**KIRKLEES METROPOLITAN COUNCIL
INVESTMENT & REGENERATION SERVICE**

DELEGATED DECISION TO DETERMINE PLANNING APPLICATIONS

Reference No:	2022/62/92837/W
Site Address:	44, Oaklands Drive, Dalton, Huddersfield, HD5 8PR
Description:	Erection of first floor side extension
Recommending Officer:	Tom Hunt

DECISION – REFUSED

Appendix 3: Proposed Development Plan

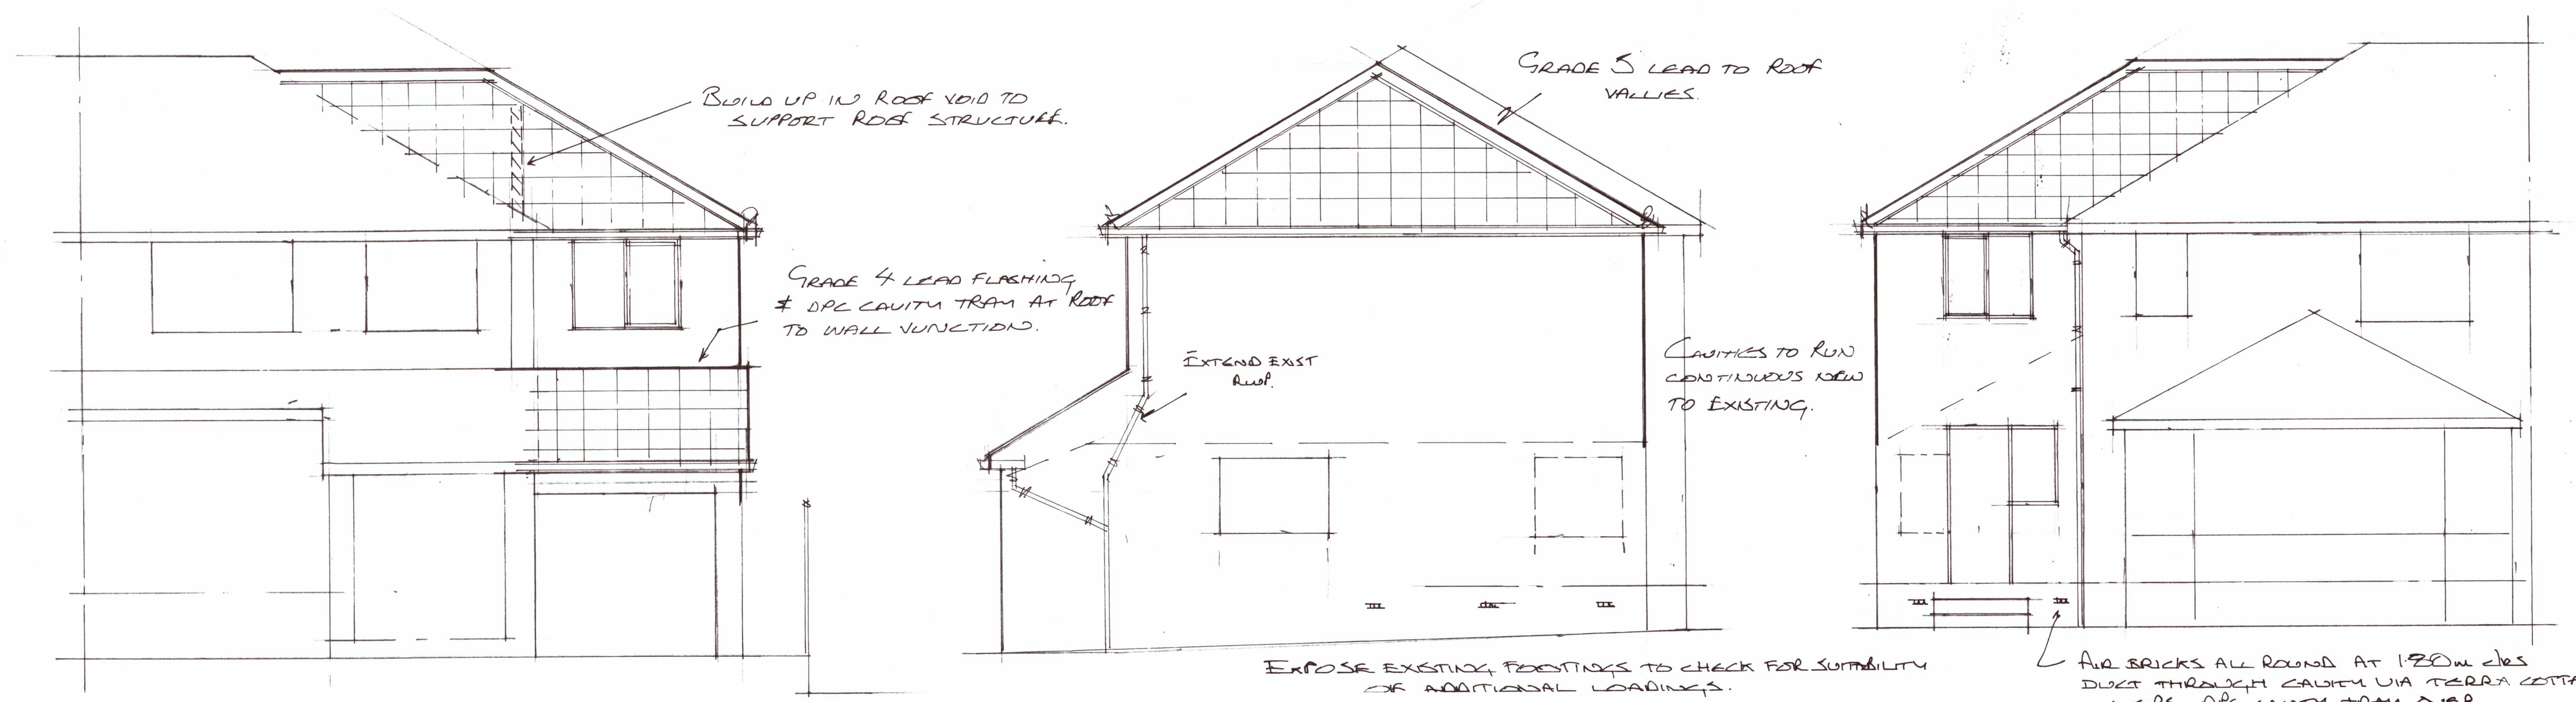
The proposed development would be over an existing single-storey side extension with an existing 0.8m gap to the boundary and be closely adjacent to no. 42's existing flat roof single-storey side extension. It would have its front elevation and front roof plane flush with the host's own, with some of its bulk slightly reduced by a set down roof ridge height. This bulk and massing to the fore, close to the neighbour and thus closing the property gap, would appear to contribute to a significant loss of openness between those neighbours and increase the risk of harmful terracing, should the neighbour wish to extend similarly. Cumulatively with the new lean-to roof design at front, the proposal would create a visually dominant and overbearing addition to the host.

As such, it would appear prominent and contrary to the existing established local character and openness in the streetscene of semi-detached properties with single-storey side extensions. Other examples of similar side extensions have been set back or have flush extensions that are not closely adjacent to neighbouring properties to ensure that the openness between properties is retained and so Officers concur that the proposal would contribute to a harmful loss of openness to the local character of the area contrary to Key Design Principle 1.

The proposed first floor side extension, by reason of its size and location close to the shared boundary, would result in loss of outlook and form an overbearing impact in relation to the first floor southeast window of the adjacent dwelling, no. 42. To permit the extension would have a detrimental impact on the residential amenity of the occupants of no. 42 and would be contrary to Policy LP24 of the Kirklees Local Plan, KDP5 and KDP6 of the House Extensions and Alterations SPD and advice within chapter 12 of the National Planning Policy Framework.

1. The proposed side extension, by reason of its design, would form an extension which is not subservient and would form an incongruous feature. To permit the proposals would be contrary to Policy LP24 of the Kirklees Local Plan, Key Design Principles 1 and 2 of the House Extensions & Alterations SPD and policies within Chapter 12 of the National Planning Policy Framework.

The case officer considered the application on review and requested amendments to the design to comply with the House Extensions and Alterations SPD. Specifically setting the first floor extension back 0.5m to achieve a more subservient design.
